To: dc.admin@kirklees.gov.uk <dc.admin@kirklees.gov.uk>
Subject: Objection to planning Application Number 2019/91141

We would like to raise an objection in relation to the proposed single dwelling on land adjacent to 320, New Hey Road, Oakes, Huddersfield, HD3 4GQ; 2019/60/91141/W.

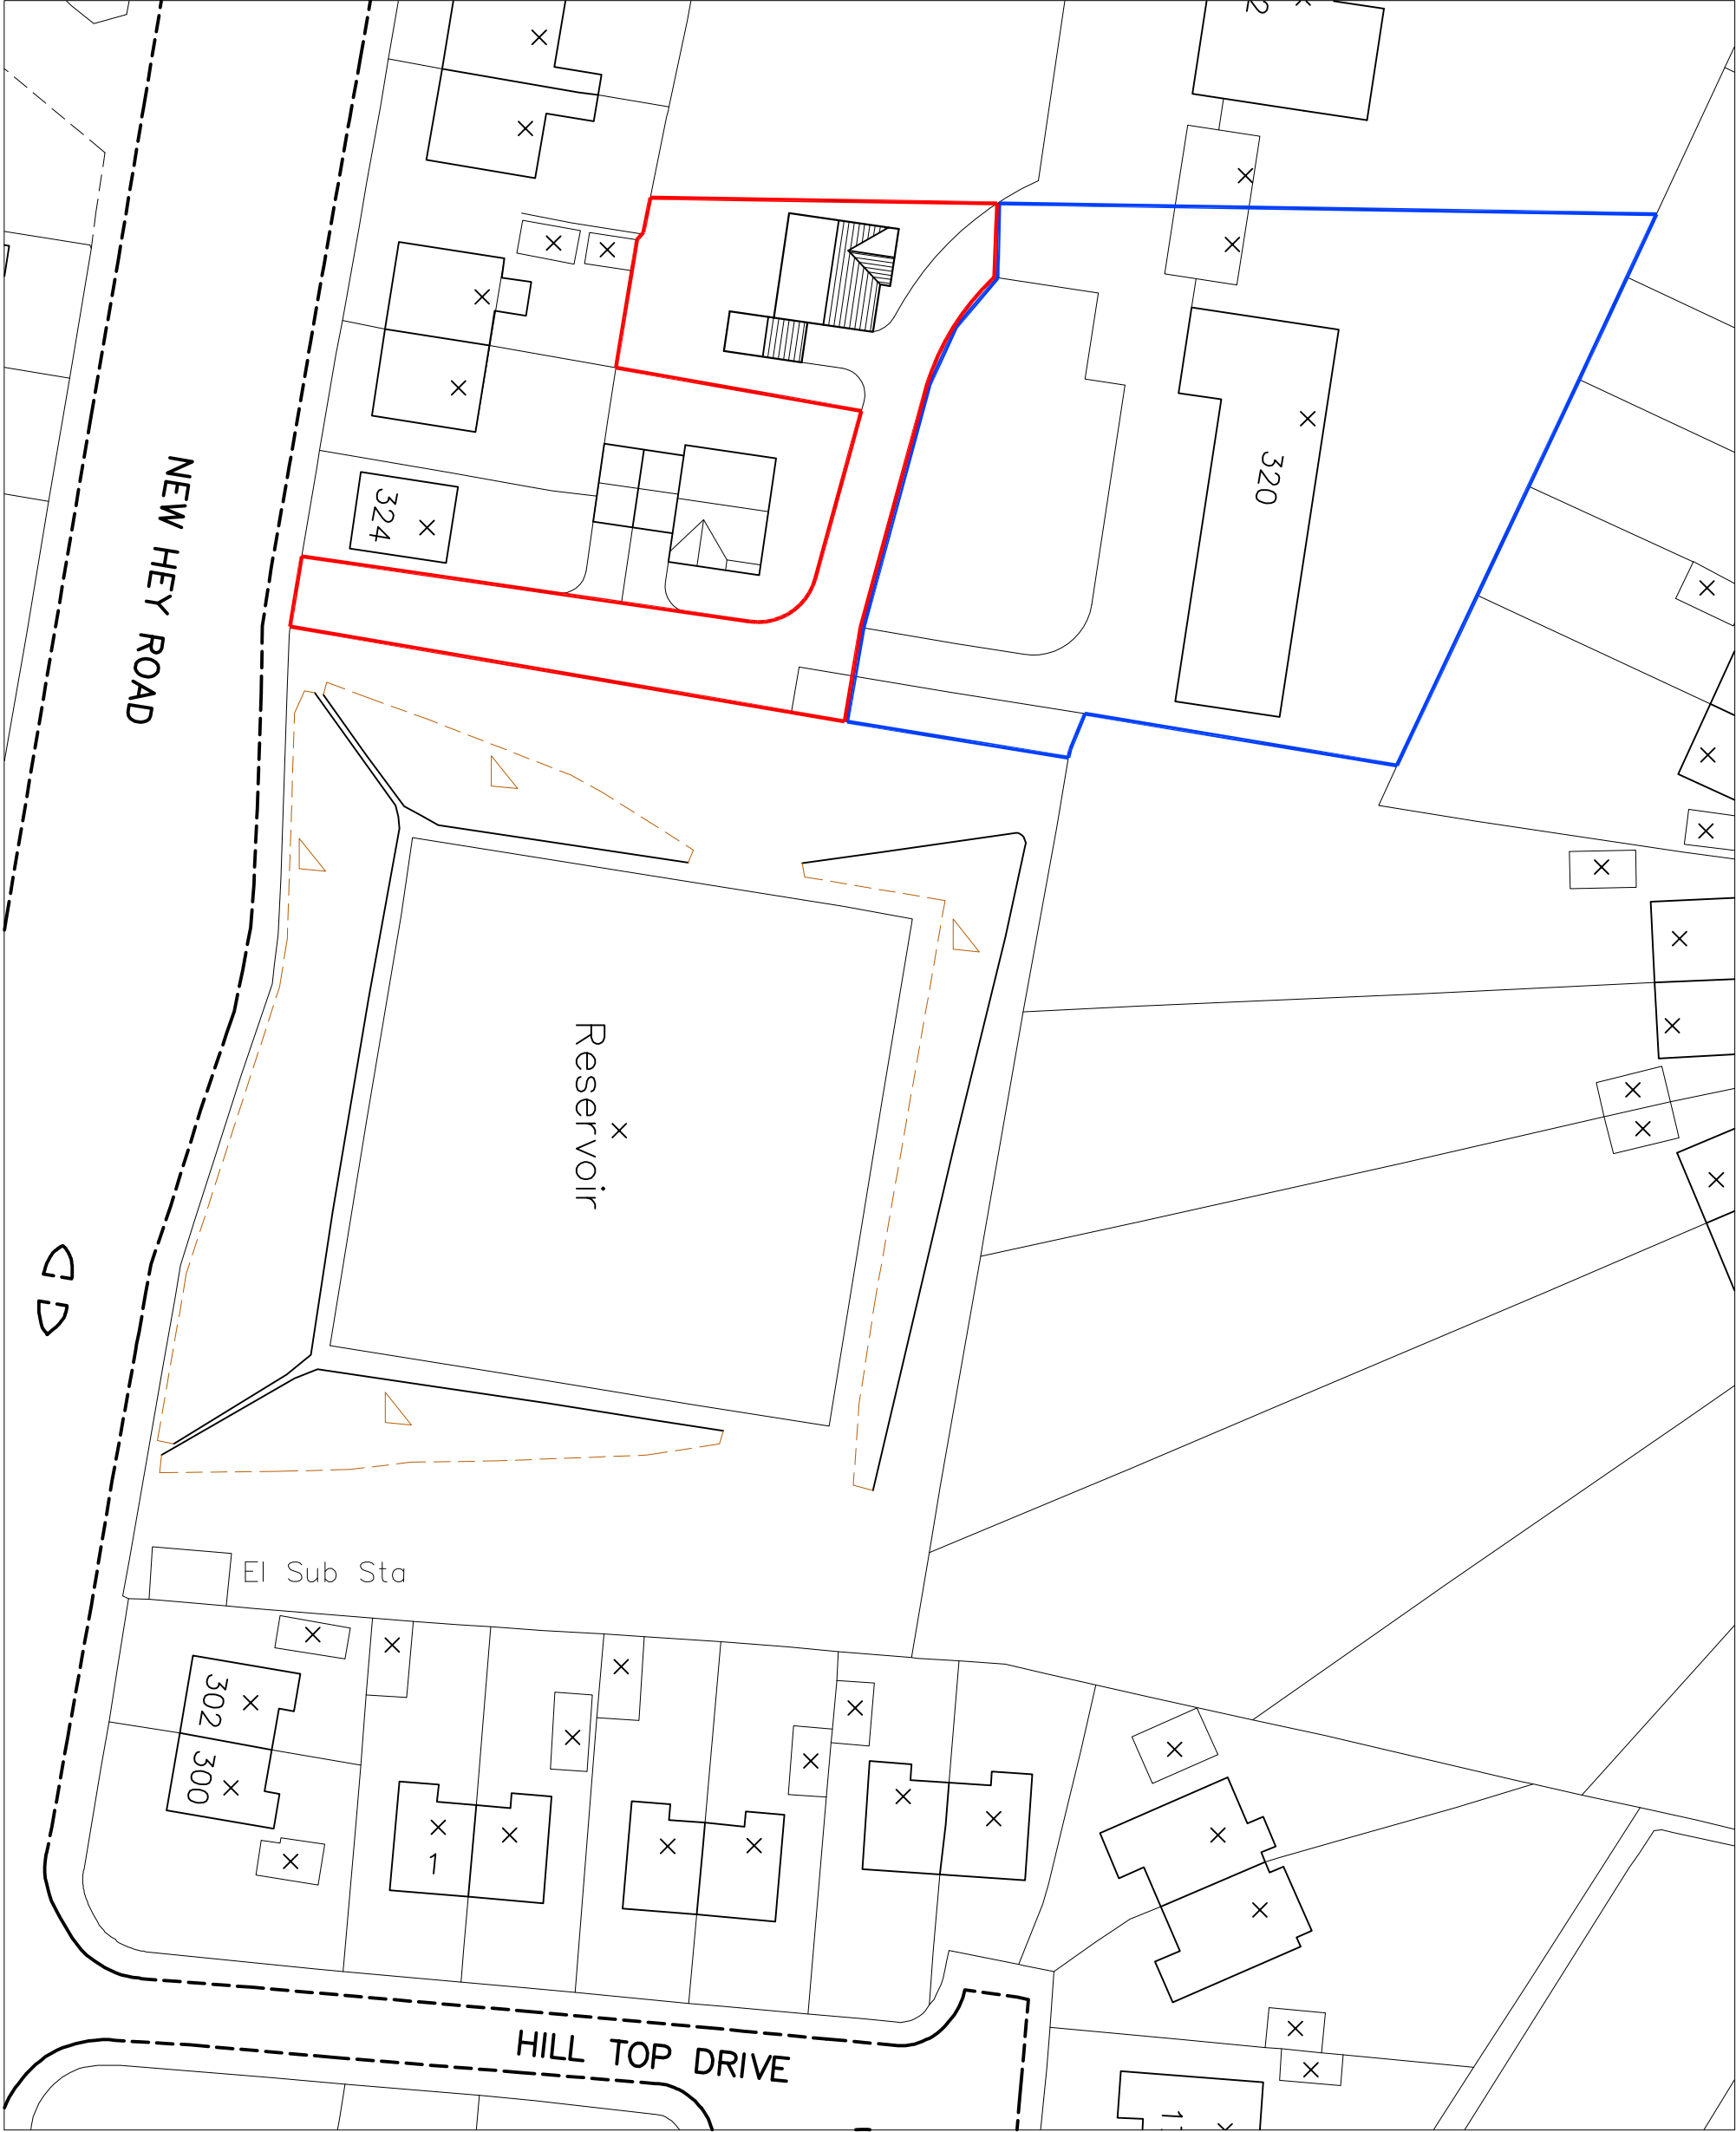
Worryingly the ordinance survey is out of date some revisions are dated 2008, with no license reference. I assume this plan has been reused from the previous applications and is supplied without the license reference being shown breaching the requirements of Kirklees council and copyright laws.

STREET ELEVATION FROM
NEW HEY ROAD

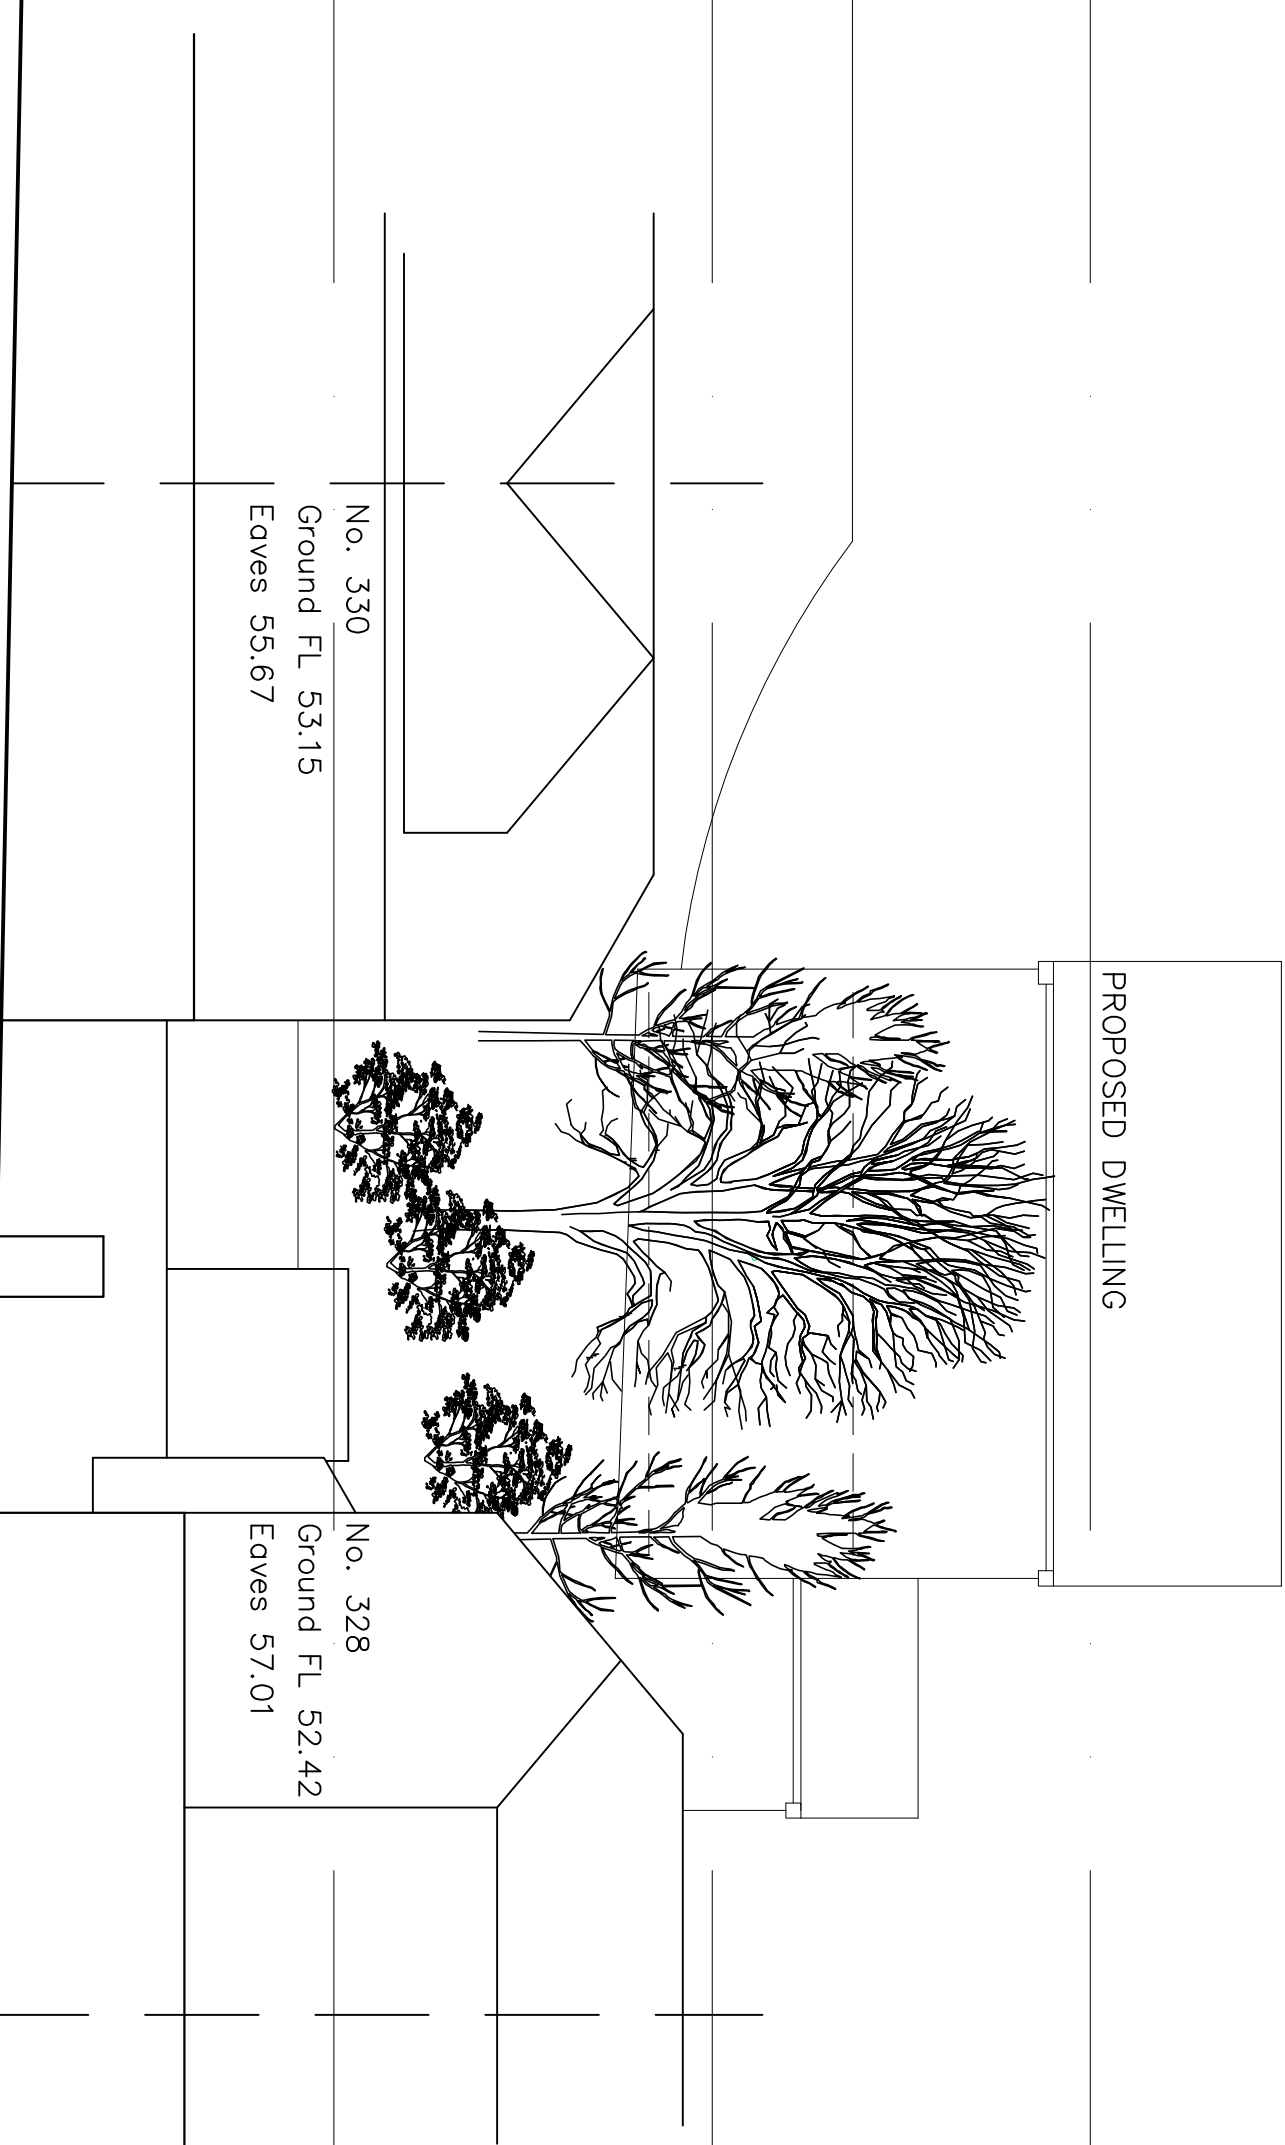
We note the dimensions on the proposed scale drawing and have cross referenced this with the previous application street scene drawing. While we note there are no windows presented at this time, one would assume there will be habitable rooms to the first floor. If any of these were to have a window facing South or East a total and utter loss of any and all privacy to the adjacent properties would occur, even considering the surviving trees and potential boundary fences where present. Due to the proximity and steep topographical position the dwelling would present as an overbearing dwelling with significant impact

on the remaining private amenity space of immediate properties to the East and South.

SITE PLAN

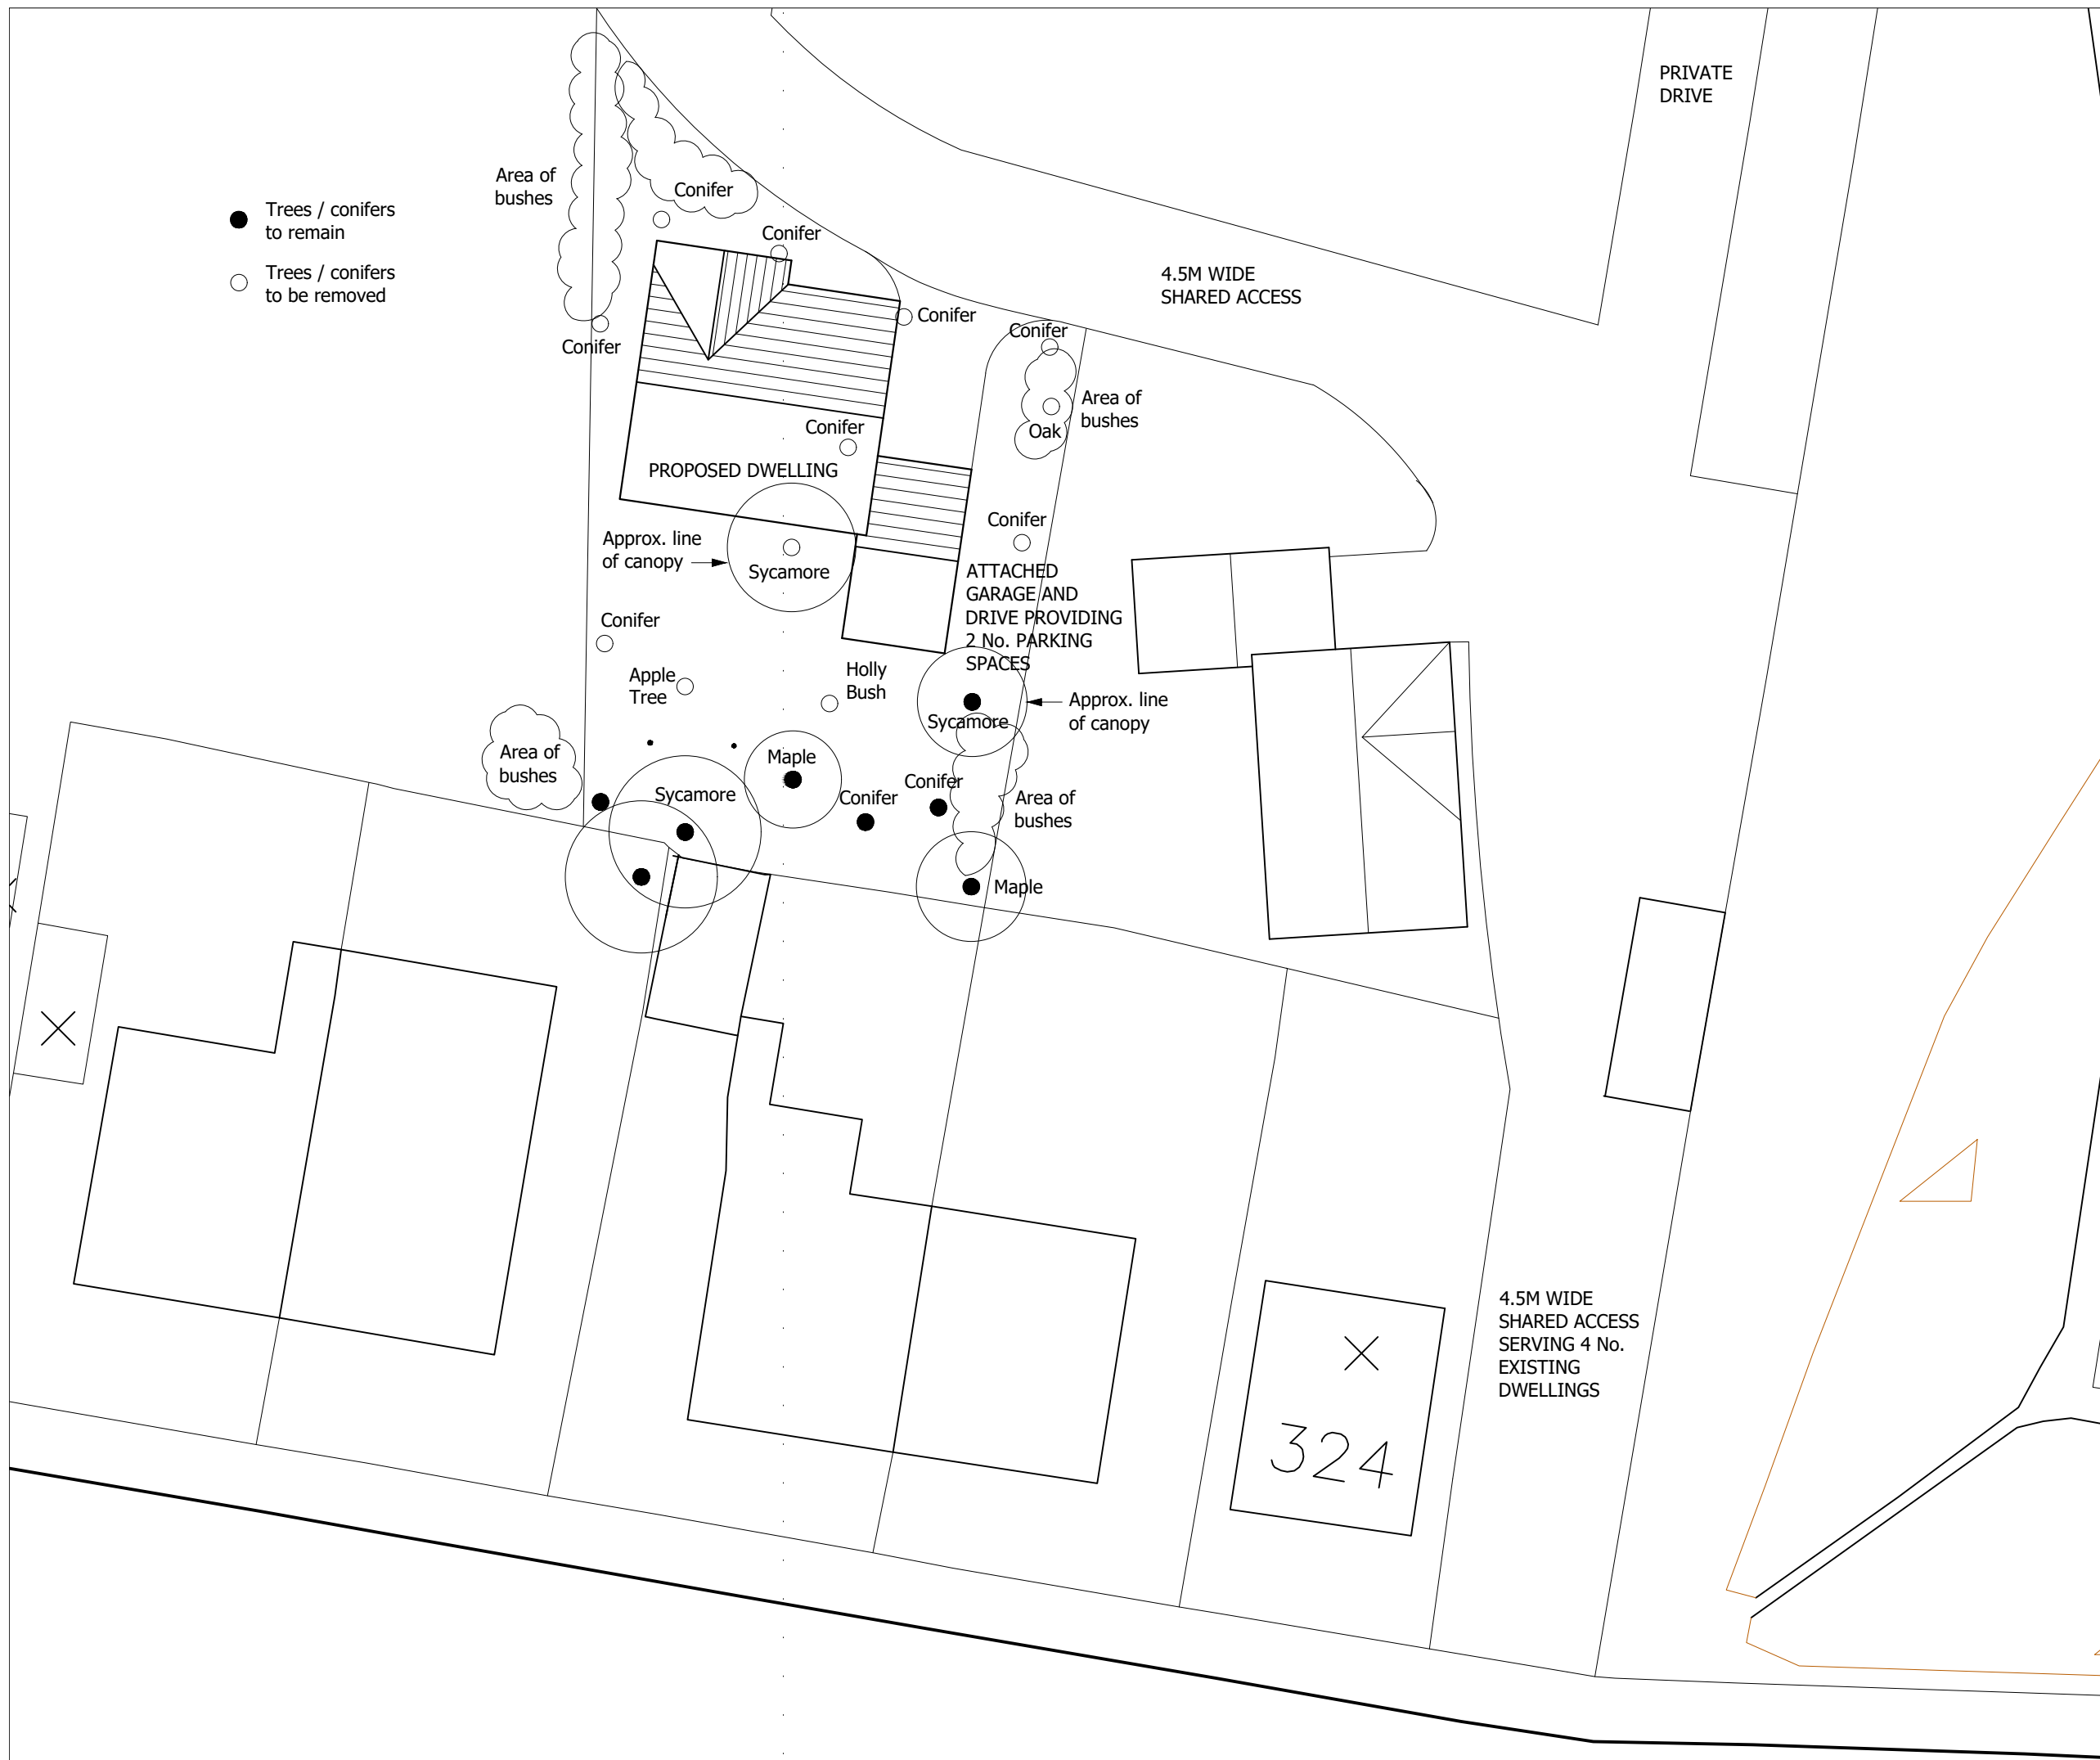
The proposed site block plan is inadequately drawn with no North arrow and demonstrates some obvious anomalies which would have bearing on any proposed dwelling;

The House to the assumed East of the proposed dwelling is orientated at an angle and is not parallel to the bungalows to New Hey Road as shown reducing the actual amenity space this property enjoys, this reduced size space will now assumingly be overlooked and lose significant private space.

The proposed block plan shows the trees in locations that do not correspond with the locations on site, giving a false representation of where the house might finally be sited.

House number 330 has an extension to the rear which accommodates a dining and kitchen area (habitable room) which is closer to the proposed dwelling than is currently indicated.

We have measured this, and it would be no further away than 15.617 Metres if the block plan is drawn accurately. Please see attached drawing.
